Application Ref:	2025/0340			 Ribble Valley Borough Council www.ribblevalley.gov.uk
Date Inspected:	Various.	Site Notice:	23/05/2025	
Officer:	EP			
DELEGATED ITEM FILE REPORT:				APPROVAL

Development Description:	Prior notification for enlargement of dwelling by construction of one additional storey.
Site Address/Location:	36 Painter Wood, Whalley Old Road, Billington BB7 9JD.

SHEET: PROPOSED SITE PLAN

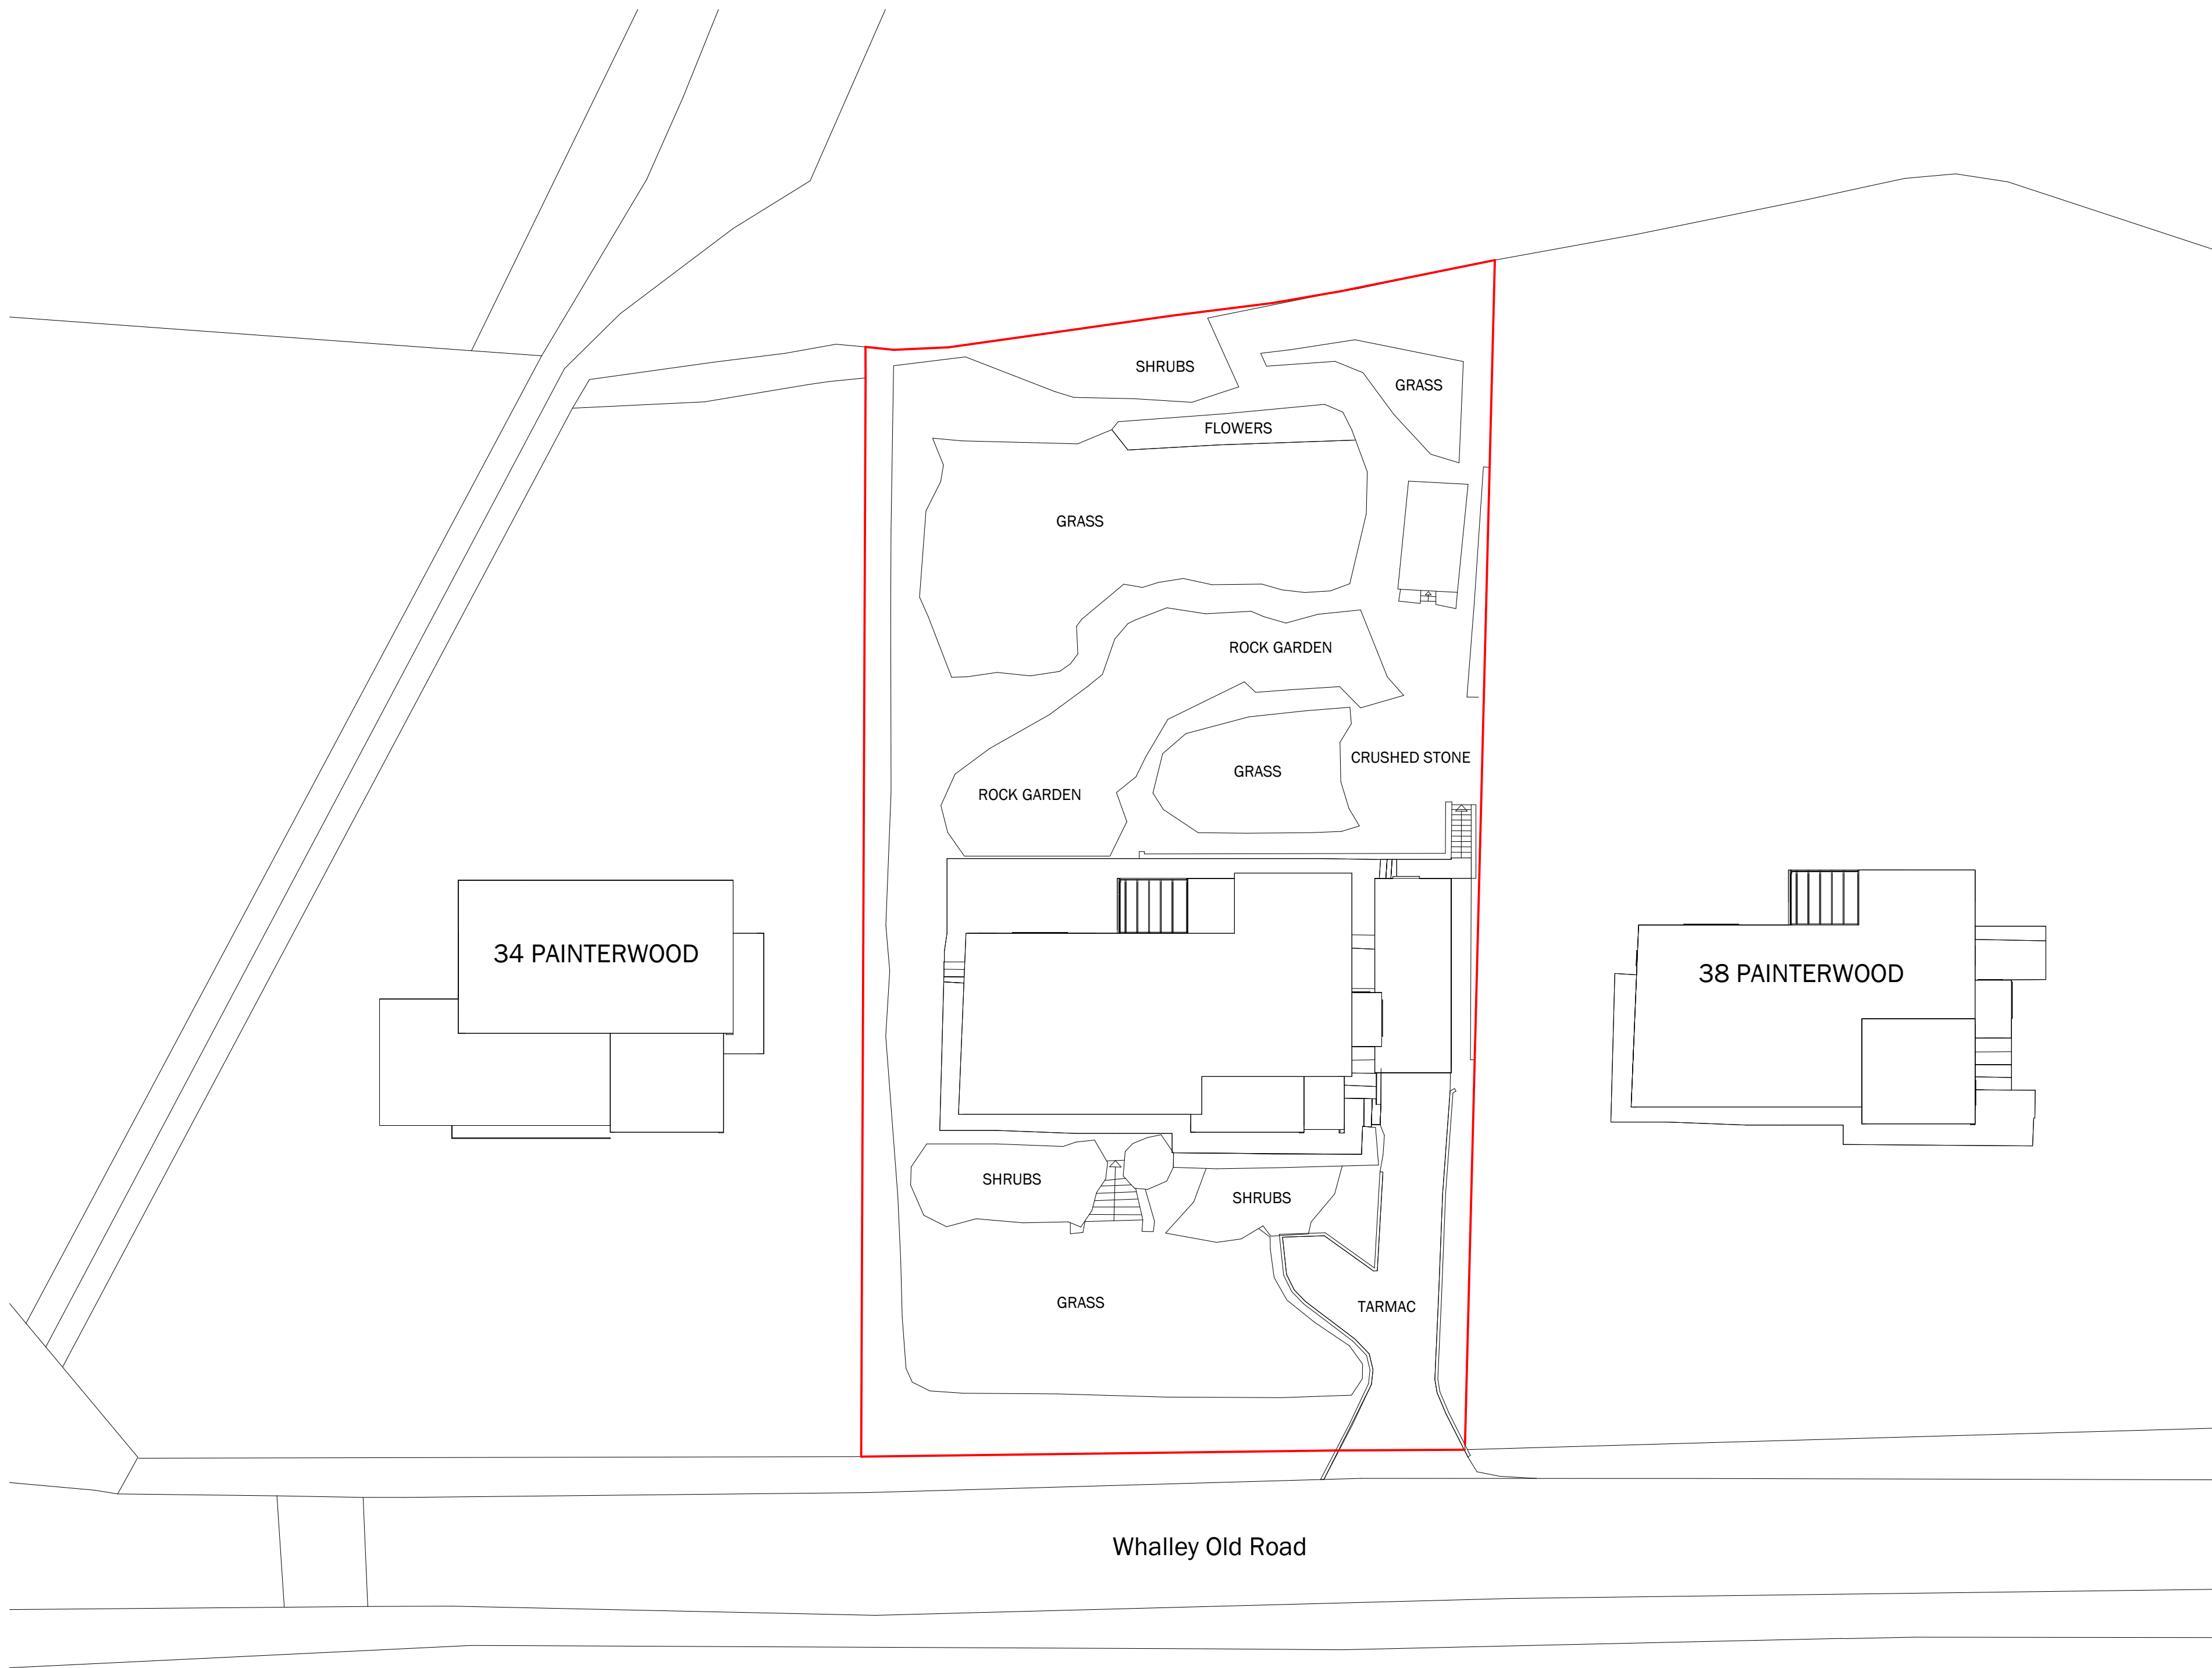
The application dwelling has two adjacent neighbouring dwellings. No.34 Painter Wood is located to the northeast of the application site. No.34 is on a lower ground level than the application dwelling, however the property has been reconstructed and benefits from additional storeys. Given the application dwelling as existing is a bungalow, the addition of a storey would not result in the property becoming substantially taller than No.34. As such, it is not considered that there would be any significant sense of overbearing or loss of light that would warrant refusal. The window openings proposed on the North elevation are consistent with those found on the application dwelling and as such there will be no new opportunity for overlooking onto no.34 created resultant.

The second neighbouring property, No.38 Painter Wood, is located to the southwest of the application site. No.38 benefits from an increased ground level in comparison to the application dwelling. As a result, following the proposed development, the application dwelling will only be marginally taller than the neighbouring No.38. Given the existing attached garage and single-storey outrigger located to the side of the application dwelling are to be retained as single storey, there will be sufficient separation distance between the proposed two-storey element and the neighbouring dwelling to mitigate any adverse impact.
